Subject: RE: AL/81/19/PL - D2, Paddock View

Simon J Davis MRTPI | Principal Planning Officer, Planning Department, Directorate of Place, Arun District Council |

Drawing 2 / 4	
All drawings are copyright of BKM architectural plans and drawings service and may not be reproduced without prior permissions

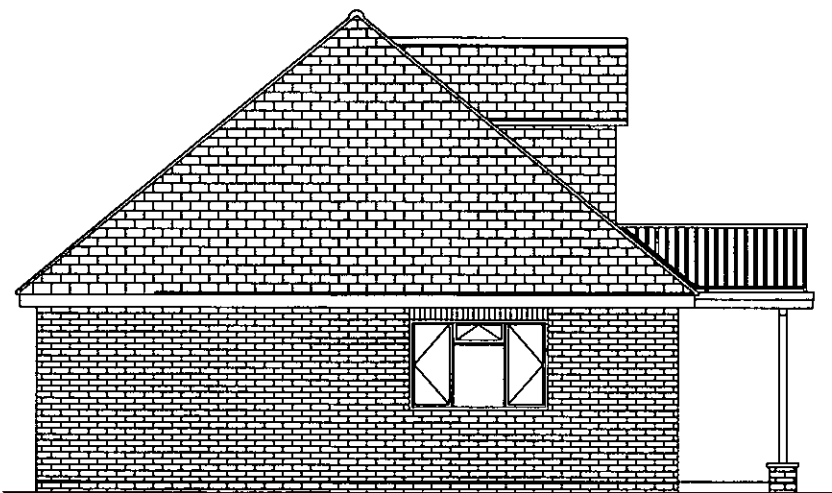
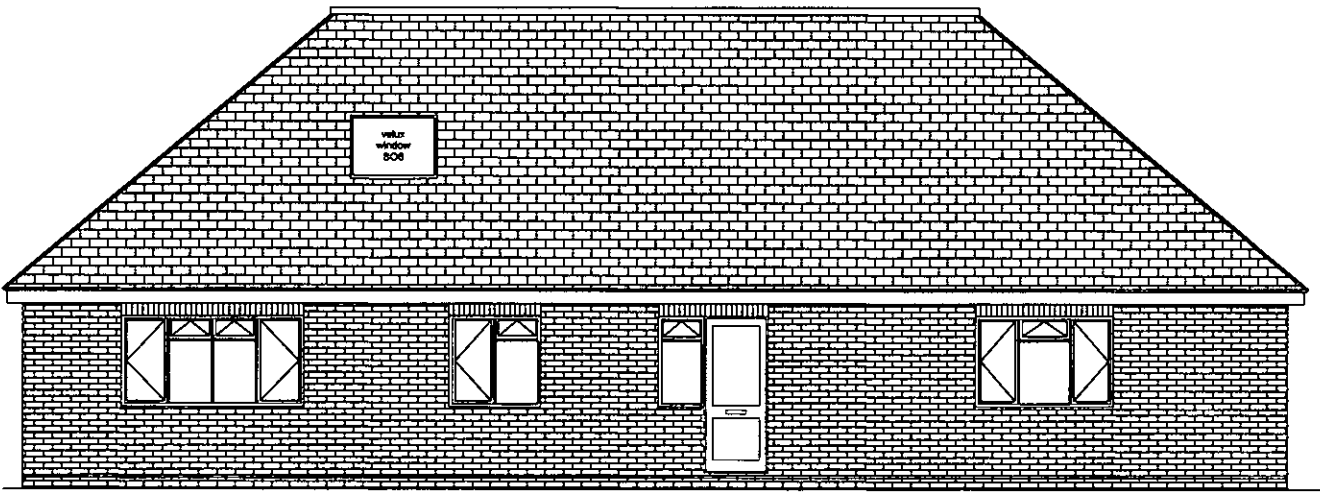
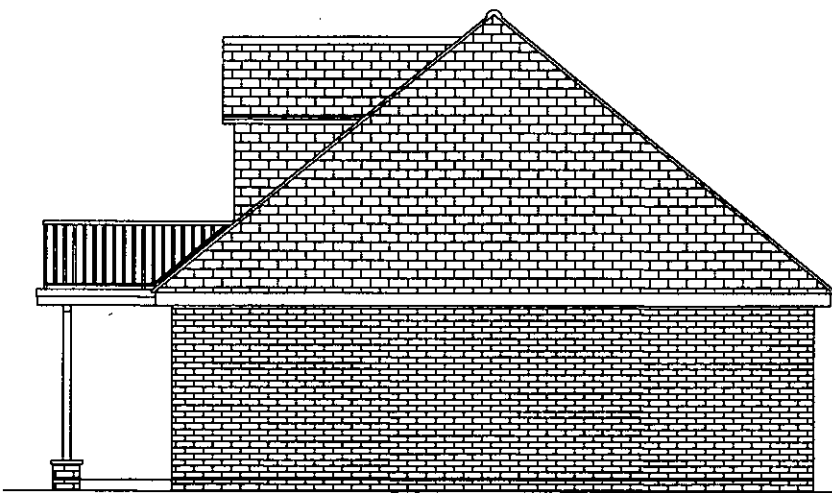
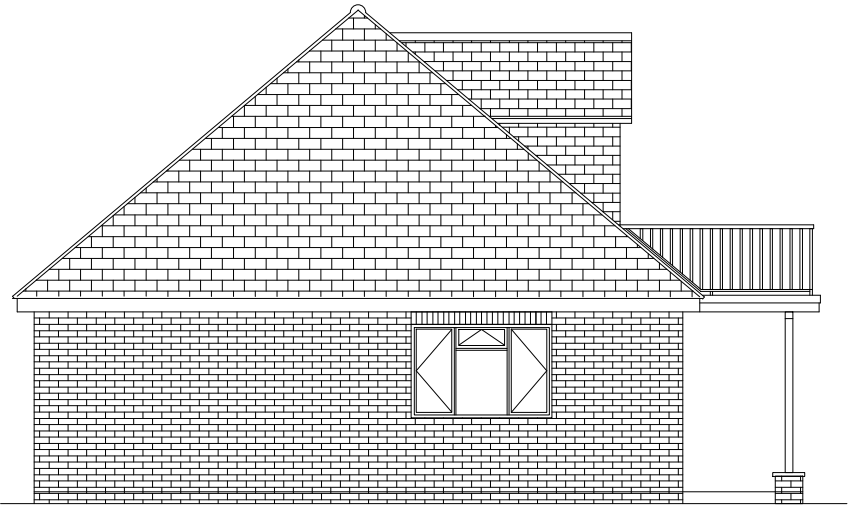
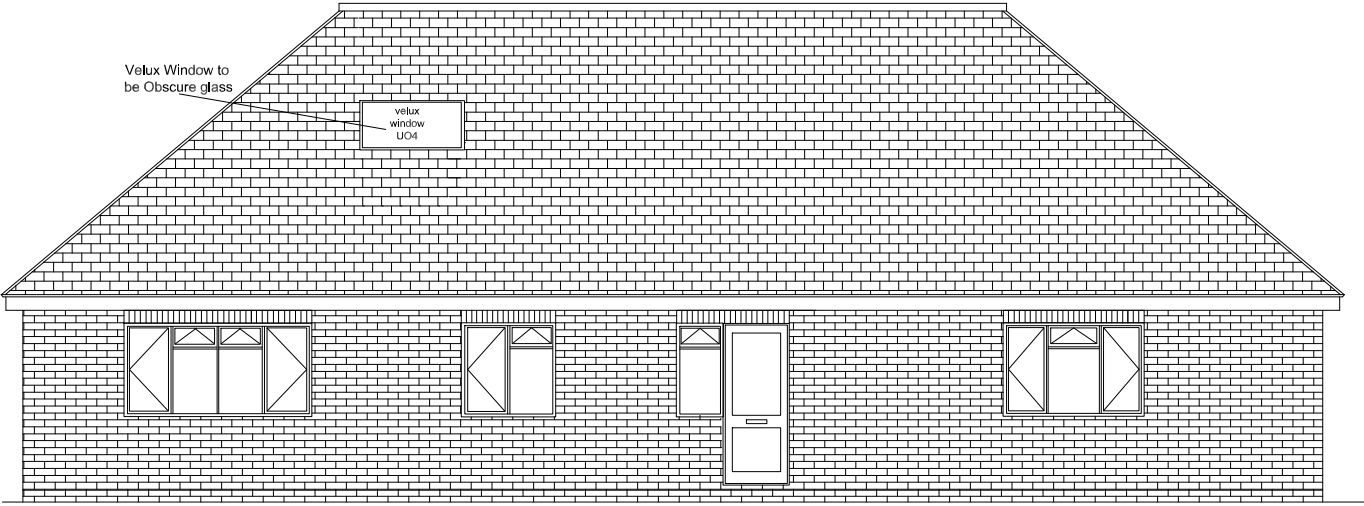
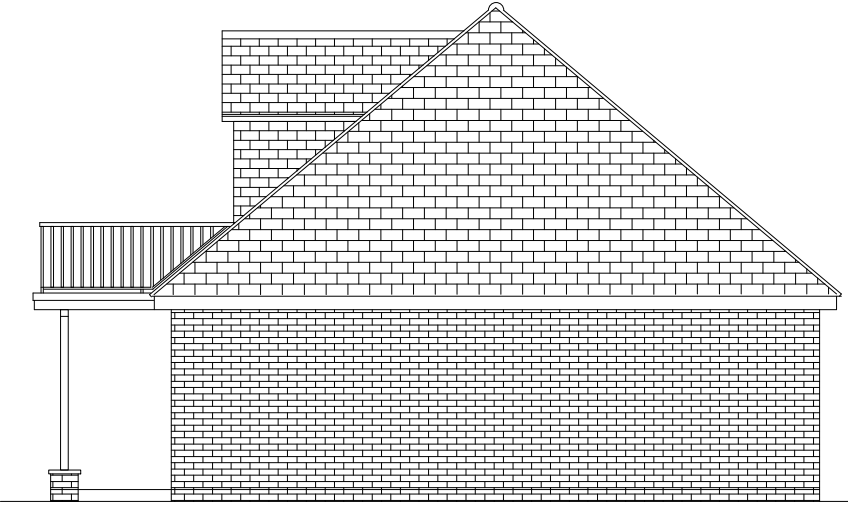
Can you amend the drawings to mark it as obscure glazed. Can you also ensure that the sill height is at least 1.7m and can you show this on the section drawing.

I note on the plans that a velux window is shown in the rear elevation which could potentially permit overlooking of the neighbours property. Is this window strictly necessary?

The velux window was chosen in preference to a dormer, being a bathroom it will have to have obscure glass (not noted on plan). I will have to rely on your discretion, please let me know if a revised plan is required.
